DELEGATED ITEM FILE REPORT - APPROVAL

Application No:	3/2012/0254/P (LBC) & 0255 (PA)
Development Proposed:	Conversion of barn into one dwelling at Chadwicks Farm, Settle Road, Bolton-by-Bowland

Ground Floor Plan

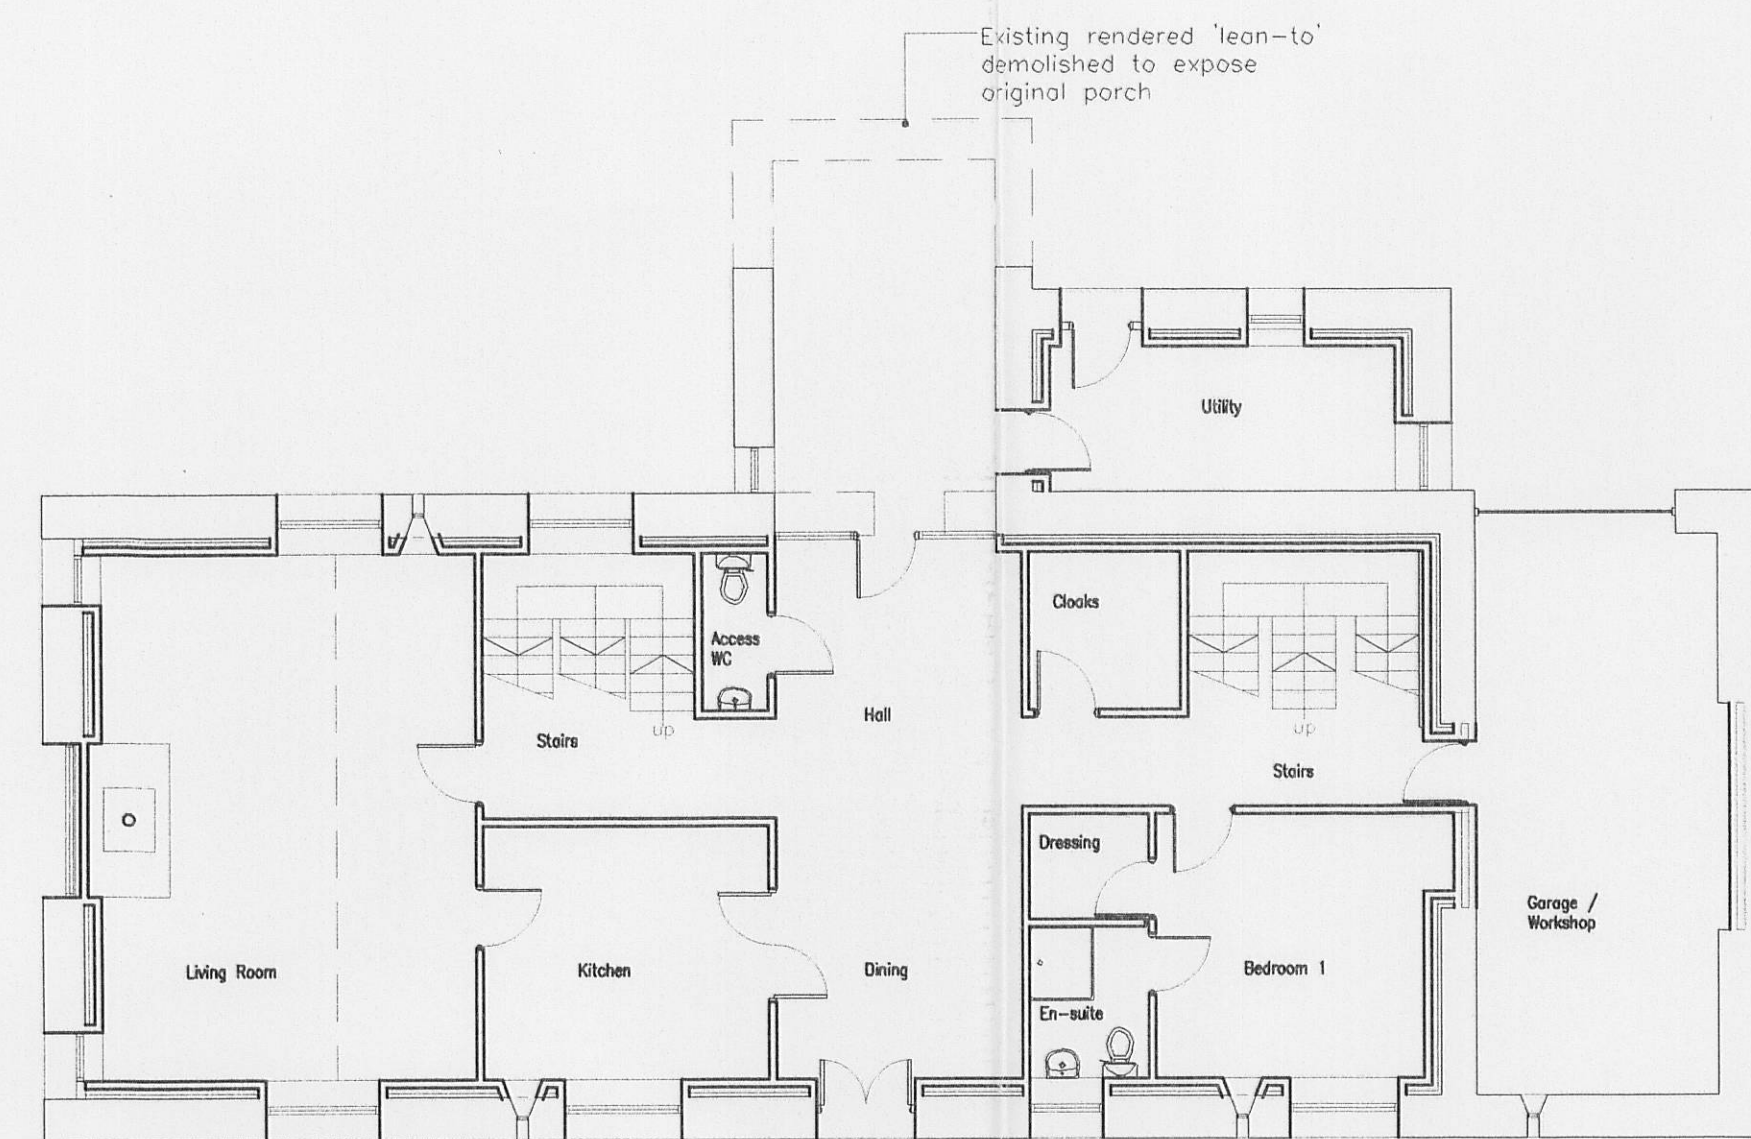
In my opinion, the scheme now proposed is based upon a thorough understanding of the significance of the historic agricultural building and is acceptable. The scheme includes enhancements to the significance including exposure of the original c.1700 cart door and porch and restoration of the full-height threshing bay. Whilst there are also losses to the significance including removal of important evidence for the changing historic usage of the barn e.g. unblocking of the second cart door (possibly original and with two historic layers of change), these adverse impacts can be minimised by the imposition of conditions i.e. deleting unnecessary roof lights from the three full-height bays and reducing the size of the new window to Bedroom 2.

The proposal, subject to amendment by condition, has an acceptable impact upon the character (including setting) and significance of the listed building and heritage asset, the landscape and character of the Forest of Bowland Area of Outstanding Natural Beauty, residential amenity and highway safety. It is acceptable residential development in the open countryside. This is in accordance with Policies ENV20, ENV19, ENV1, G1, H2, H15, H16 and H17 of the Ribble Valley Districtwide Local Plan.
